West End Neighborhood Traffic Evaluation – 2018

~~Produced for The City of Portland~~

Cap COMMENTS 3/21/19

CSP-1

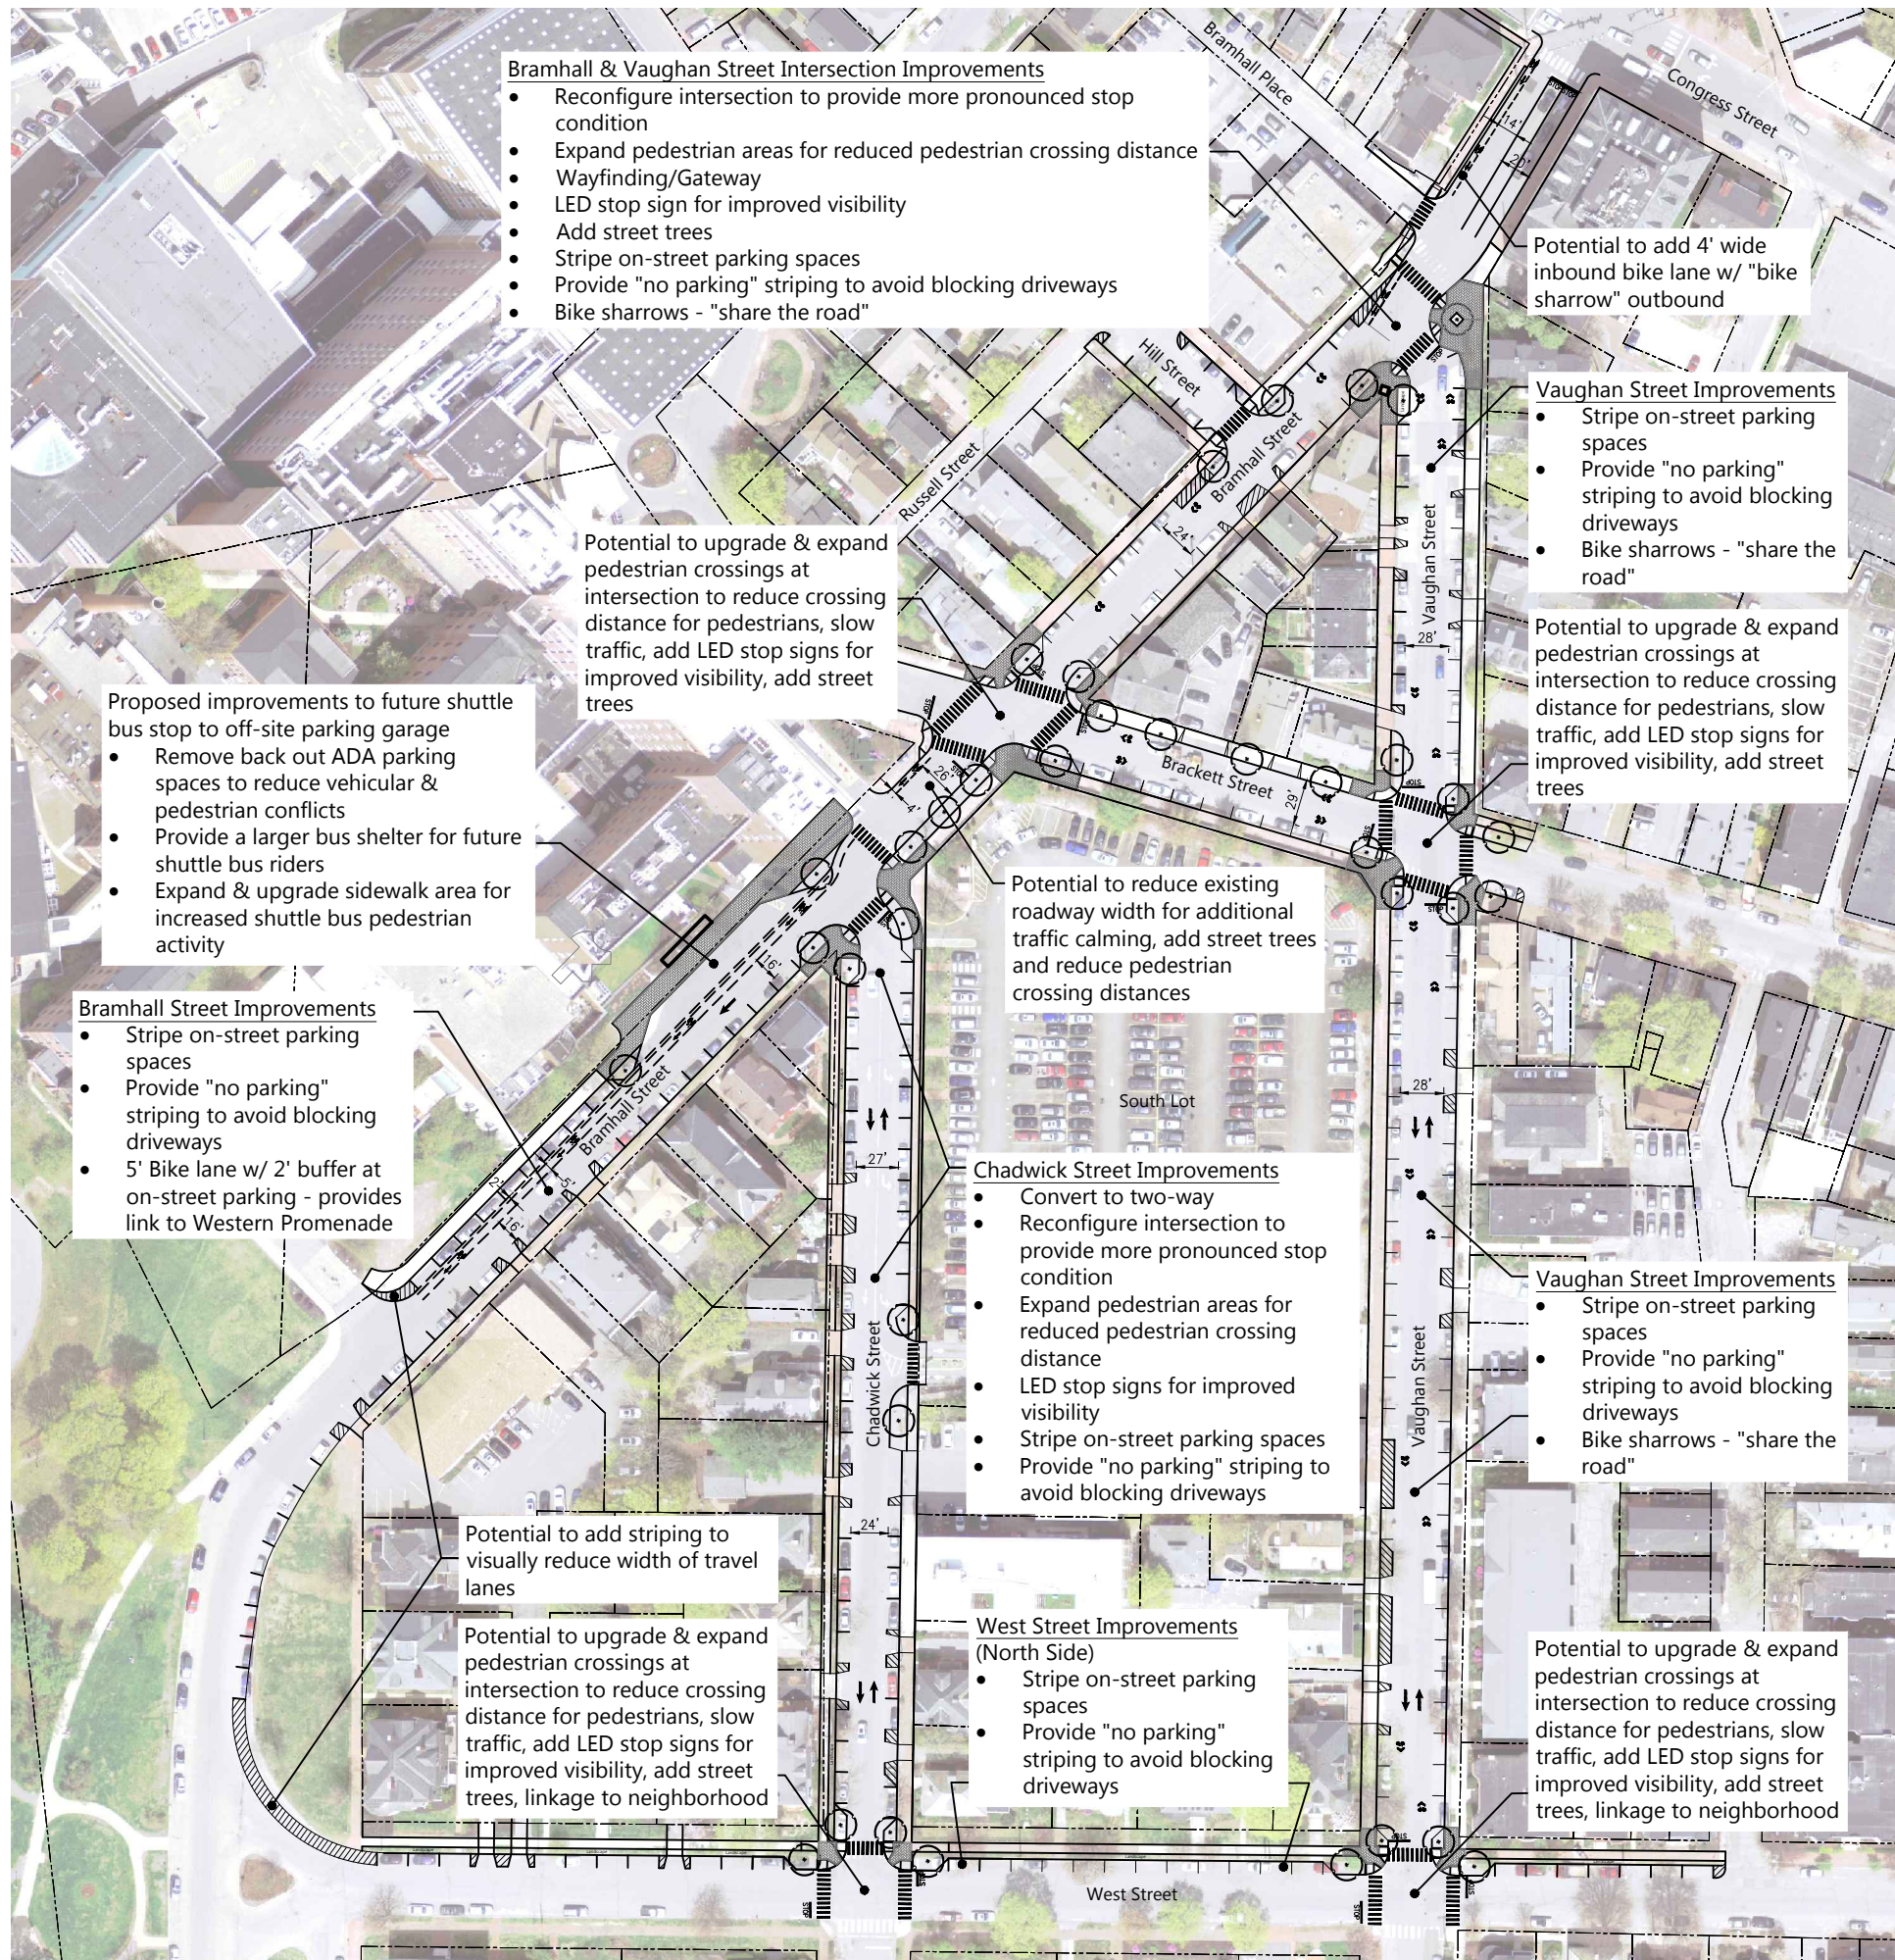
6) Mostly to bring in at right angle
Add US treatments - more ex. drain
on Bramhall
No no bike lane - use
sharrows instead.

7) We do not stripe individual spaces
Sometimes we stripe a parking lane,
but not sure this would be beneficial here.

8) Add plan for Crescent/Wescott parking
to this graphic -

9) MMC BDO AT
BDO comment - can we do anything there?
NAME ON STREET City of Portland
SIDE OF STRIPES?

1) waiting on comments from Metro - Why is this so wide? How would this accommodate Metro + shuttles?

2) Eliminate bumpout in favor of on street parallel ADA parking.

3) Eliminate bike lane + buffer in favor of sharrows

4) Show this stretch of Bramhall two-way
 23' ->
 11.5' | 11.5' P
 + address intersection + address intersection with west.

5) Add curb extensions on West
